Department of Planning and Environment

12 May 2022

Compass 2 Warehouse & Distribution Centre (SSD-30923027)
Response to Submissions

EASTERN CREEK DRIVE

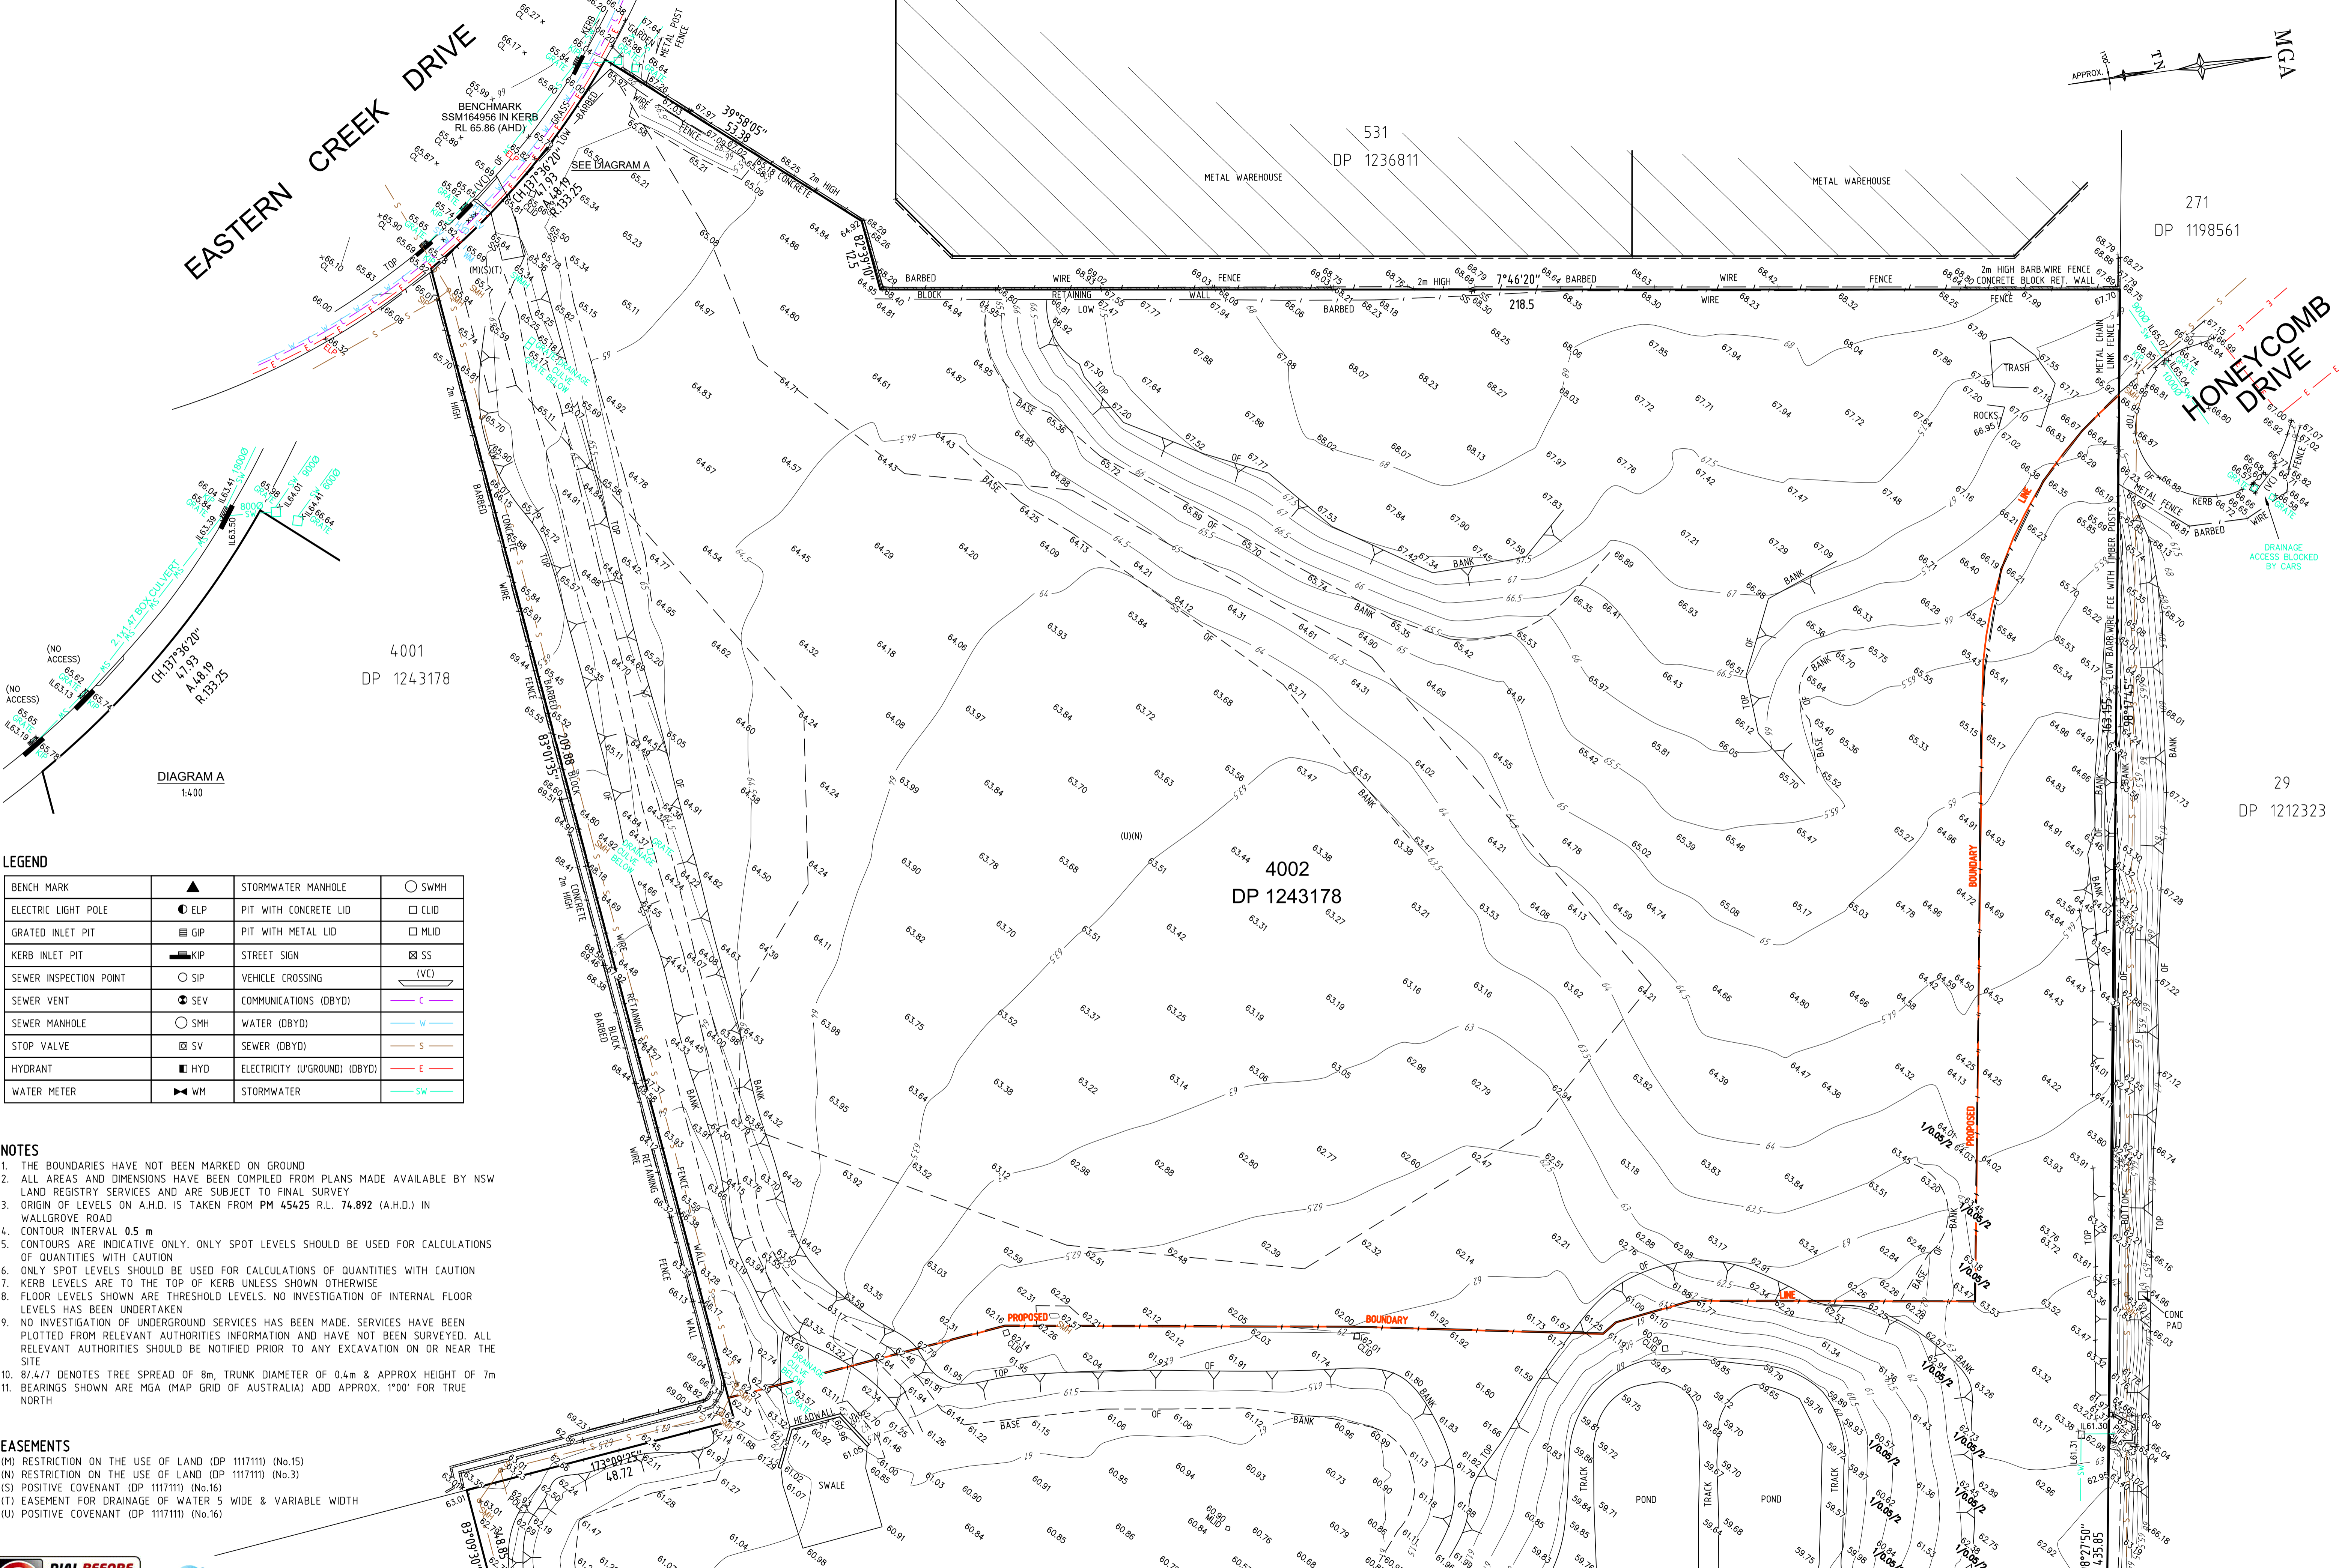
The proposed building and hardstand areas do not meet all required setbacks outlined in section 11.4 of the Employment Lands Precinct Plan – Eastern Creek Precinct. Please incorporate the required setbacks into the building and hardstand design or provide detailed justification referencing any requirements which cannot be met.

The proposed access driveway to Honeycomb Dr via LOT 271 DP 1198561 appears to be in close proximity to an existing stormwater drain and transformer. Please detail any impacts on existing infrastructure and how the impacts will be mitigated.
